Wylfa Newydd Development Consent Order, EN010007.

Comments by National Trust at Deadline 3.

Landscape Briefing Note 9 -
DCO Application: Deadline 2: Heritage Assets Plans

Project: 1011 Wylva Newydd Nuclear Power Station

Figure 6-18 Proposed land use

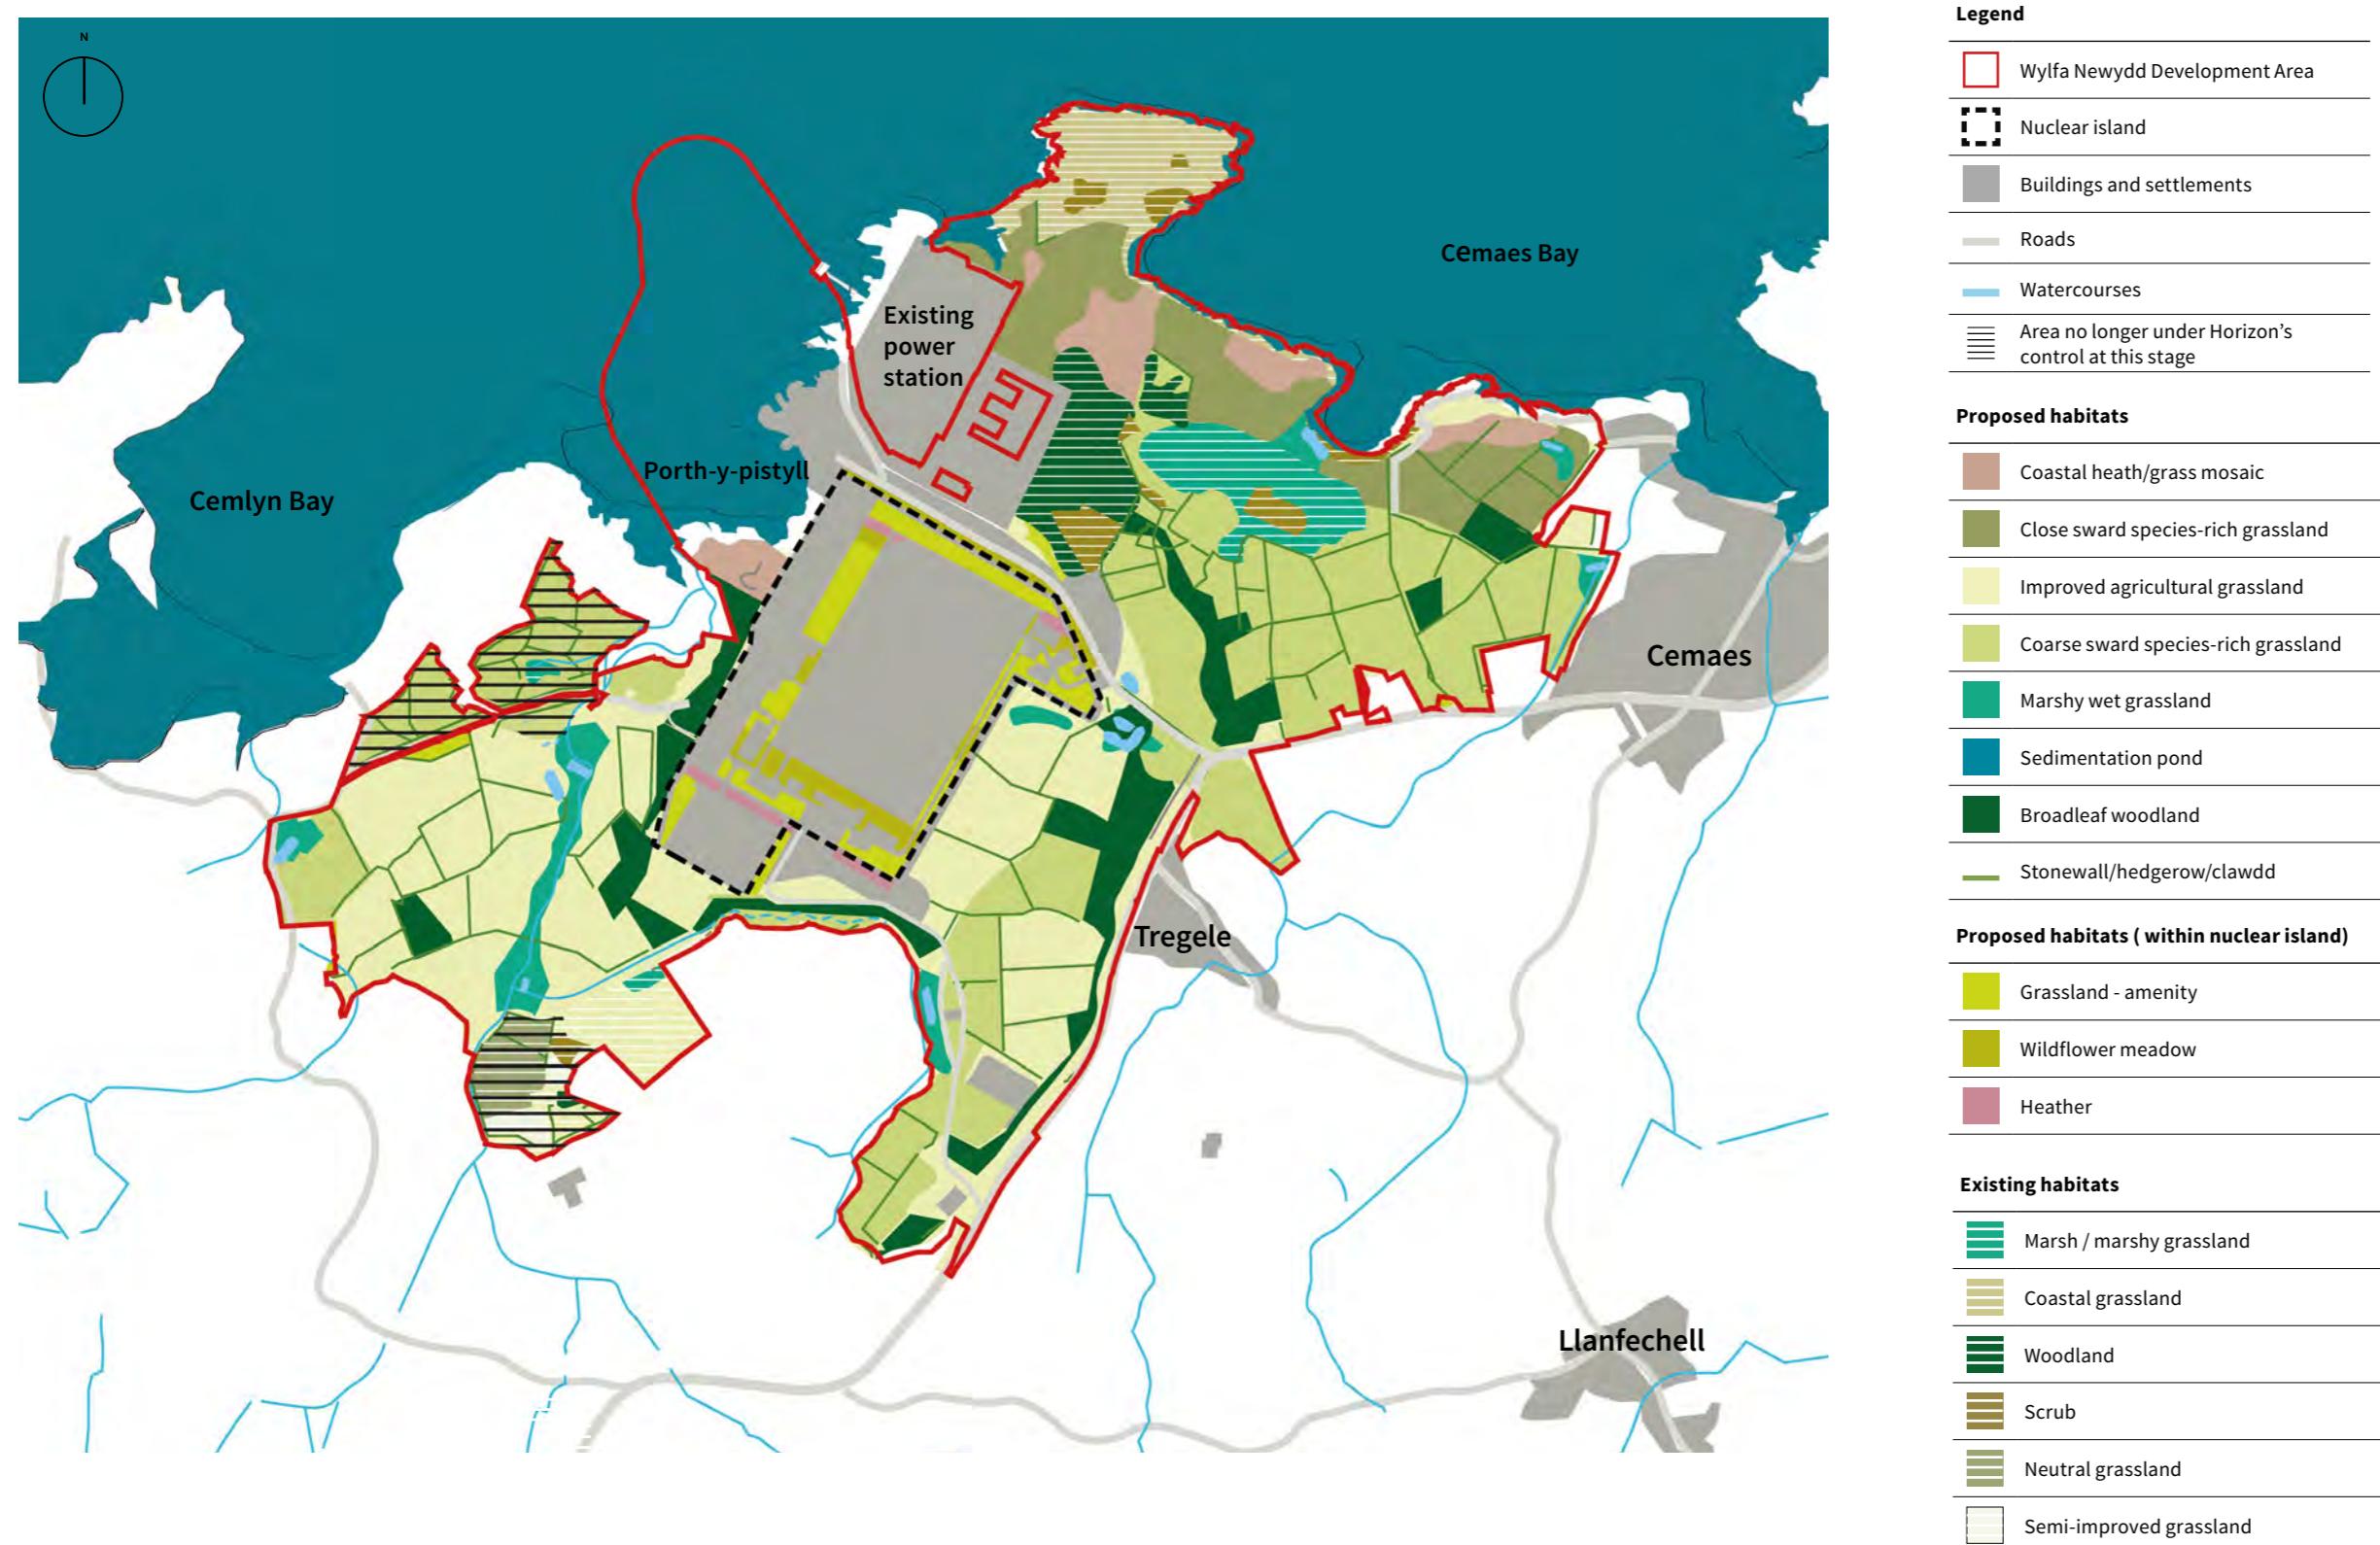
4. There are earthworks shown on *Dwg 60PO80AS _ Q6.0.17_ 01b illustrative main construction activities* and *Dwg 60PO80AS _ Q6.0.17_ 02 illustrative operational layout* north of Cemlyn Road close to the southernmost part of Cestyll Garden. It is unclear what these earthworks relate to as there are no earthworks in this area shown on the Landscape and Habitat Management Strategy (LHMS) *Figure 5-5 Illustrative landscape proposals during Main Construction* or *Figure 6-3 Illustrative plan of the restored landscape during site operation* (neither the original nor Revision 1).

5. The land immediately to the south of Cestyll Garden north of Cemlyn Road is keyed as '*Sympathetically managed agricultural grassland*'. On Figure 6-18 Proposed land use of Revision 1 of the LHMS this land is identified as '*Grazing land managed primarily for biodiversity*'.
